Erection of a first floor front/side extension, two front and two rear dormers to facilitate a loft conversion.

Amendments Summary

To Luton Council
Planning department
Your ref: FZAFFA/24/00158/FULHH

01 RIGHT SIDE ELEVATION- EXISTING
GA-201 SCALE 1:50

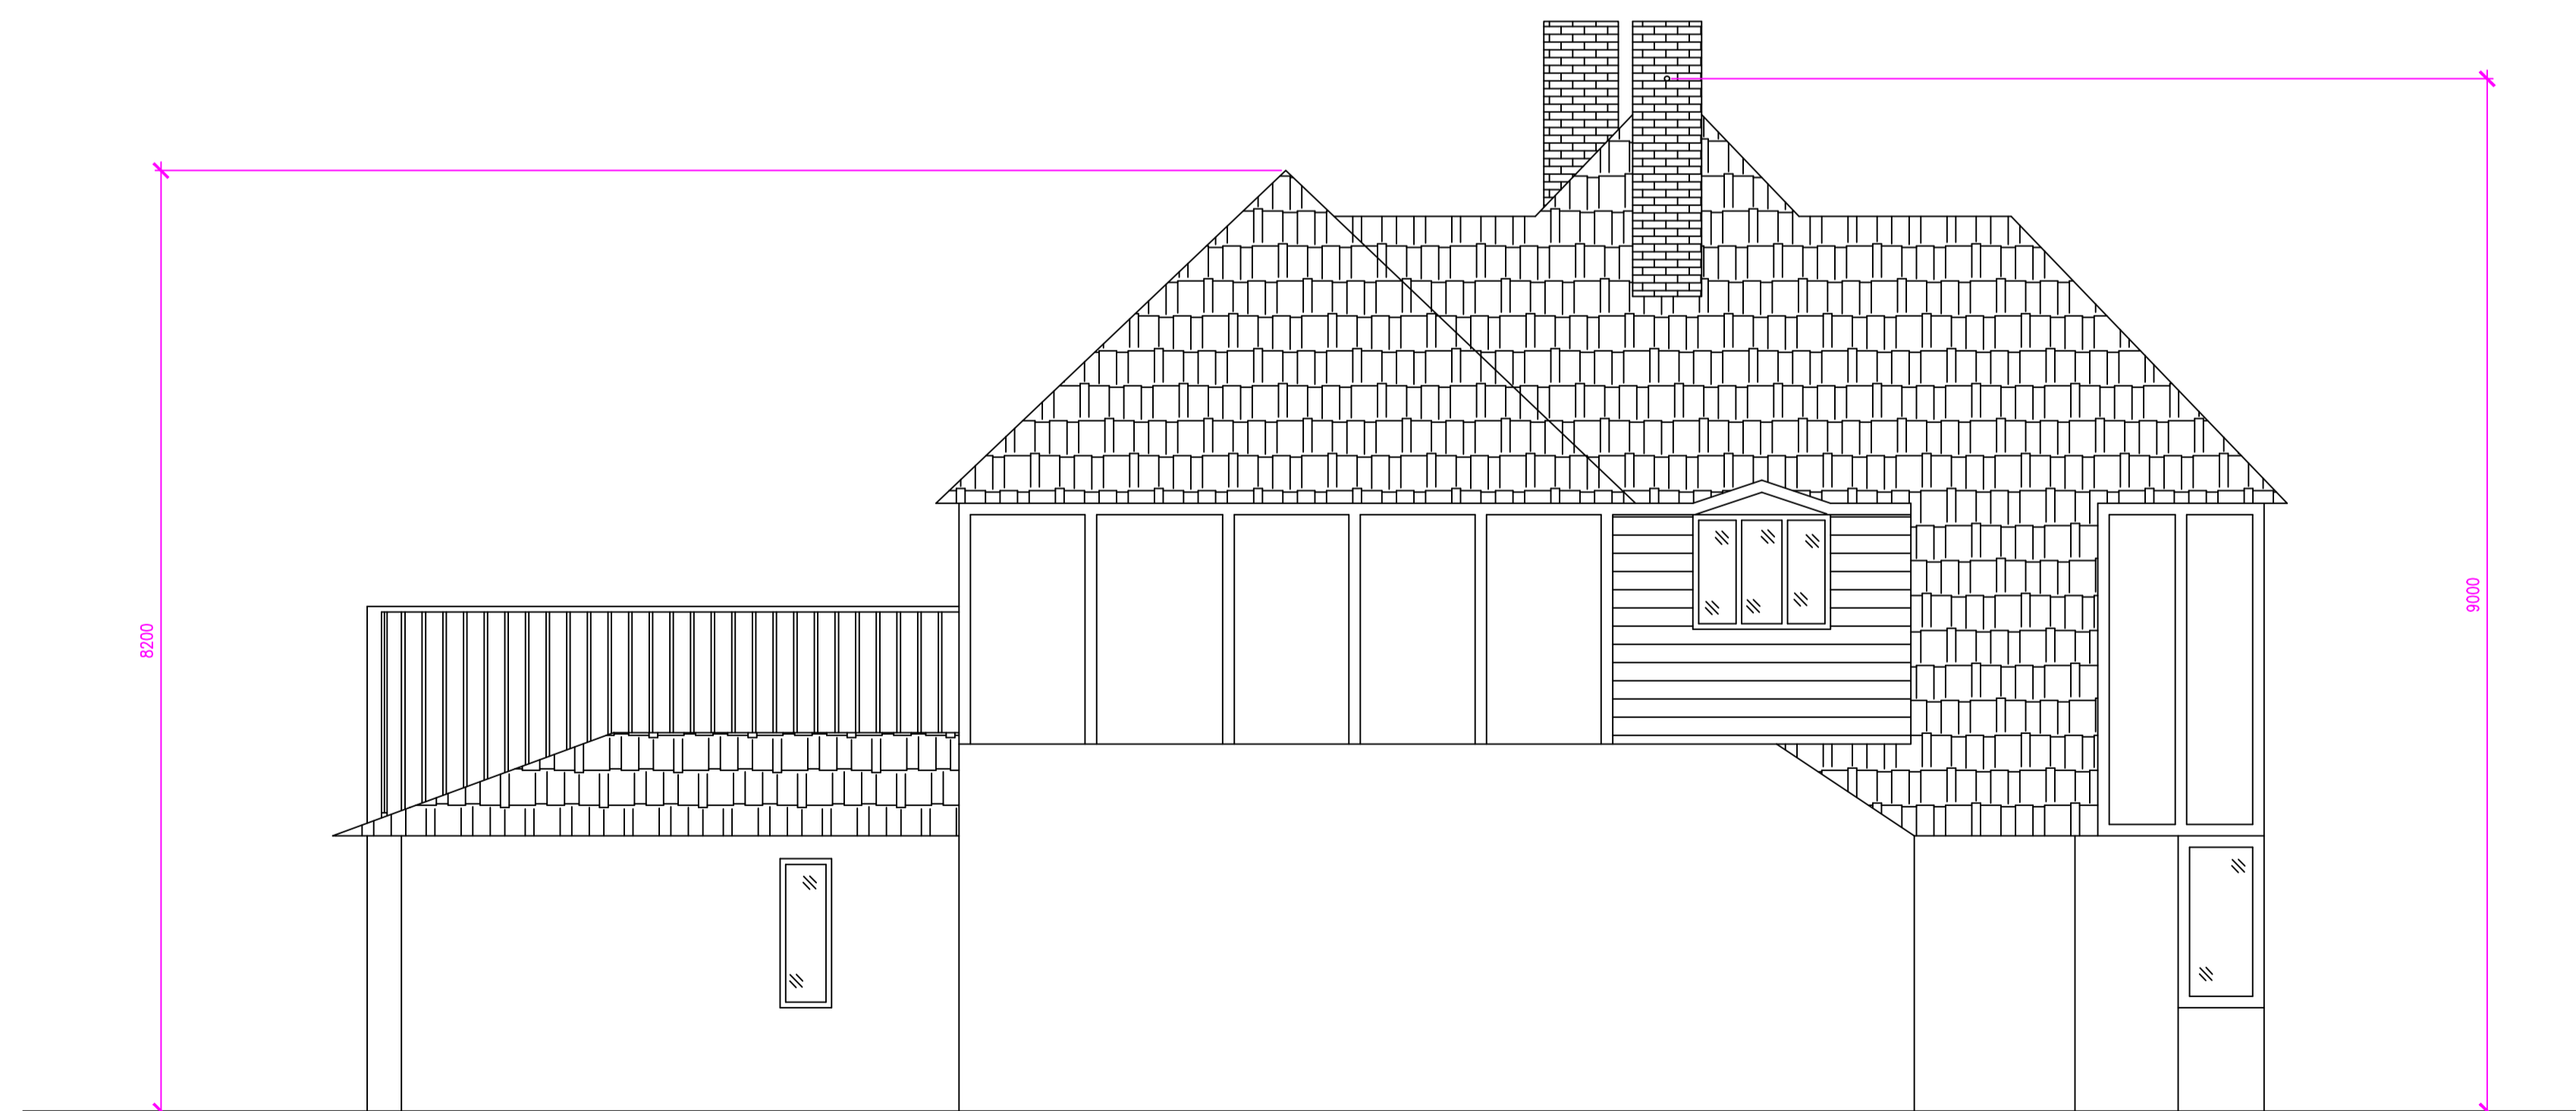
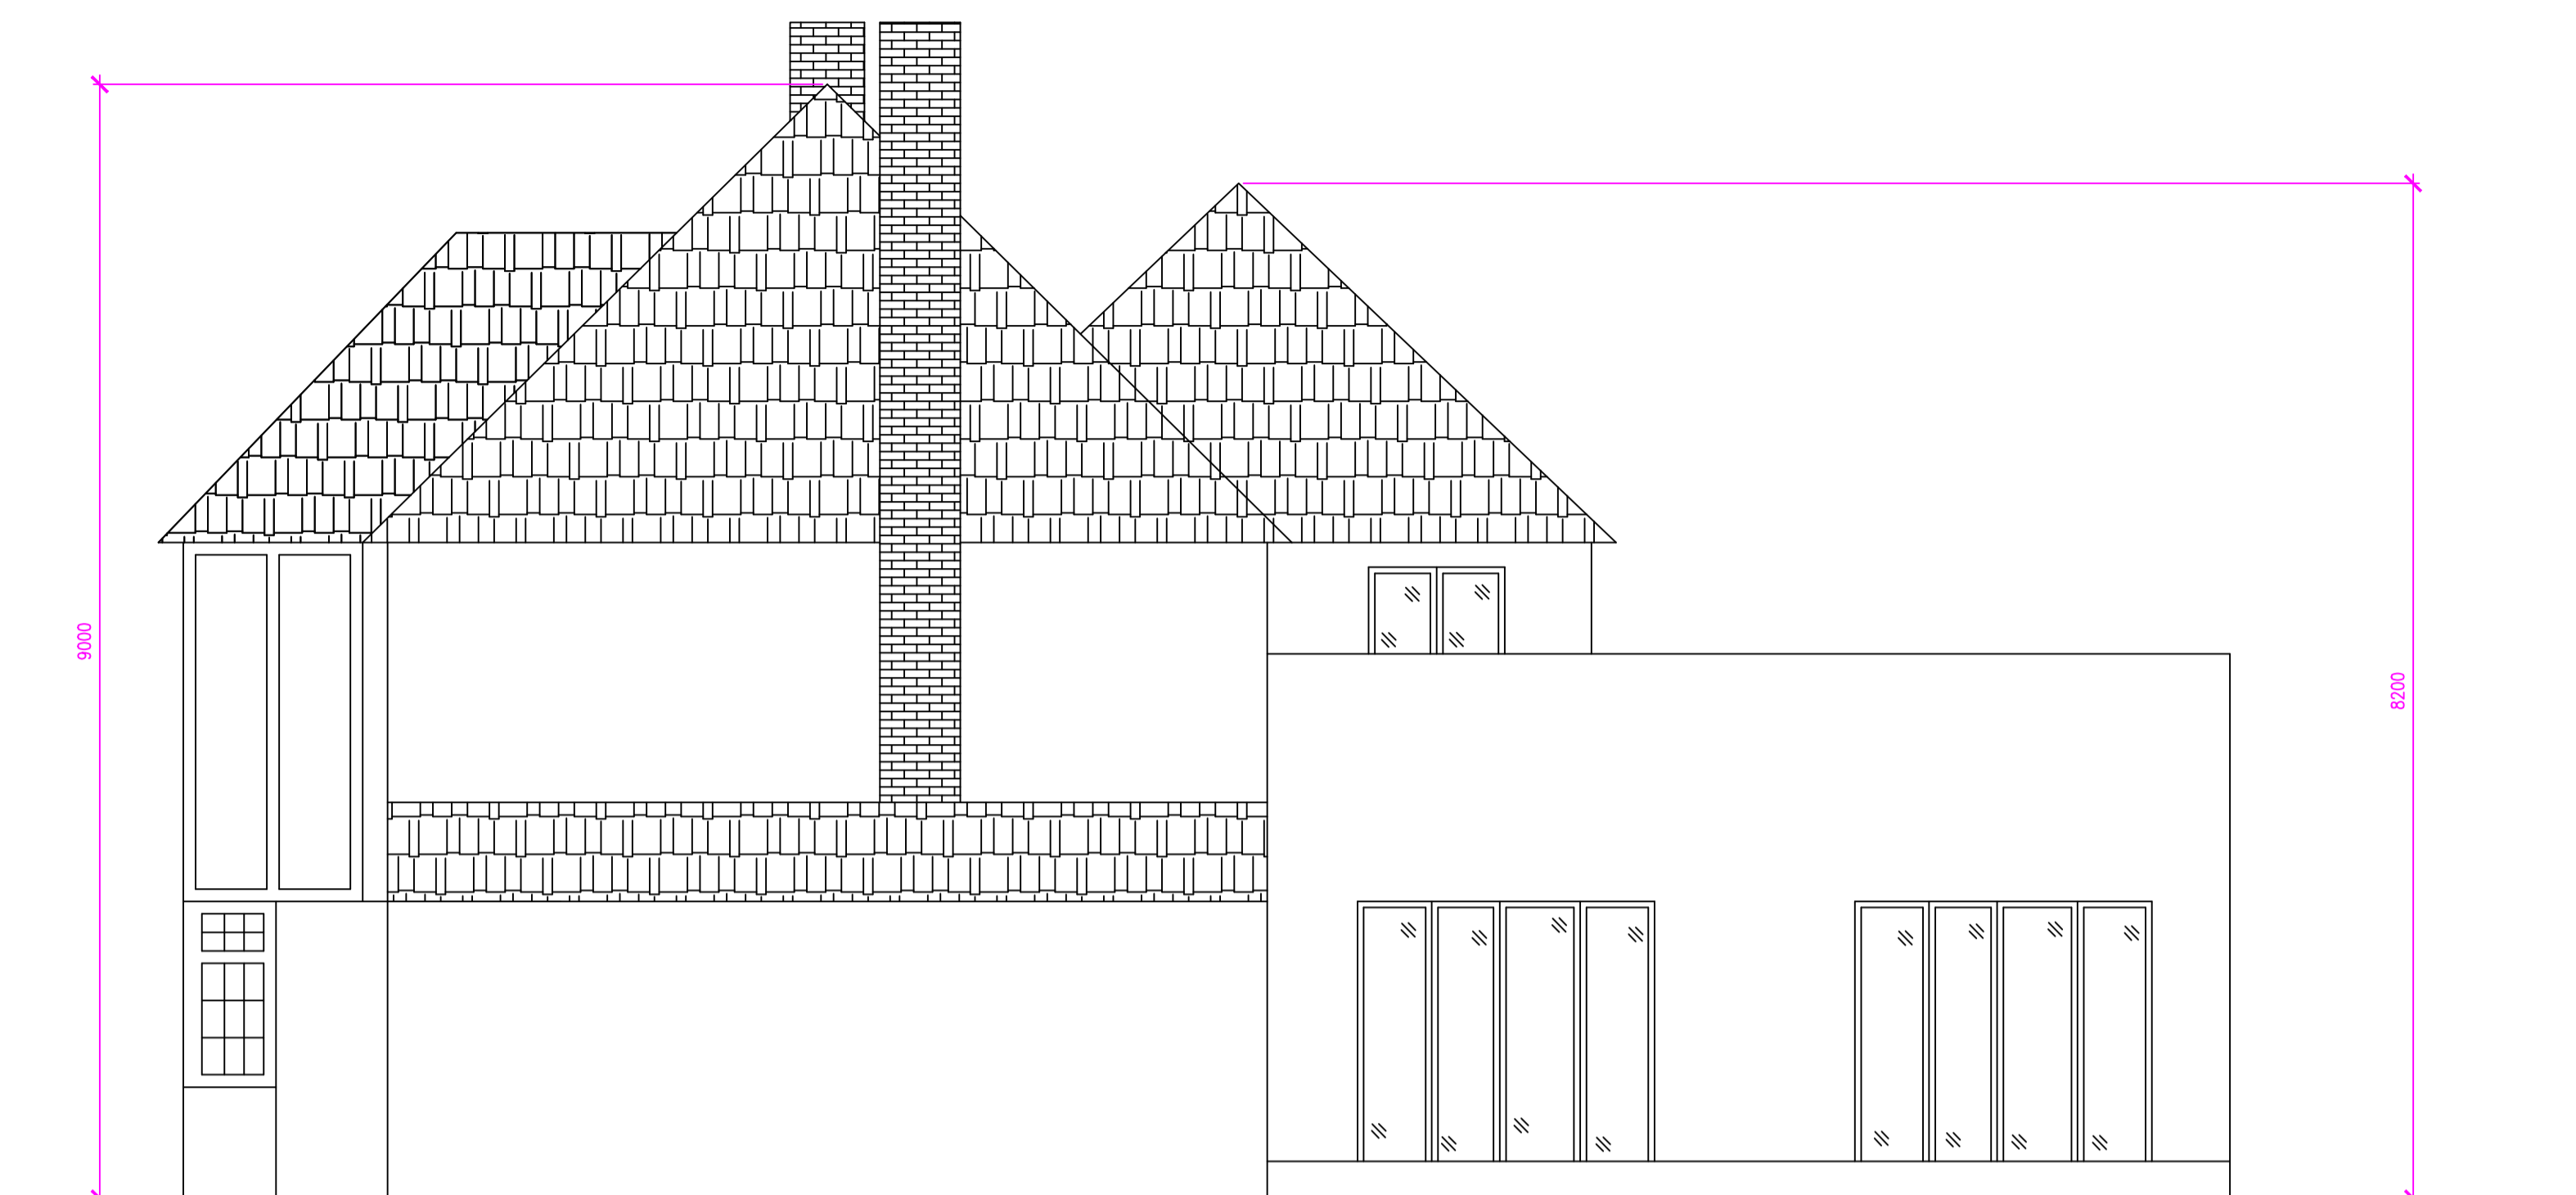
Please also supply existing side elevations

Also side elevations provided.
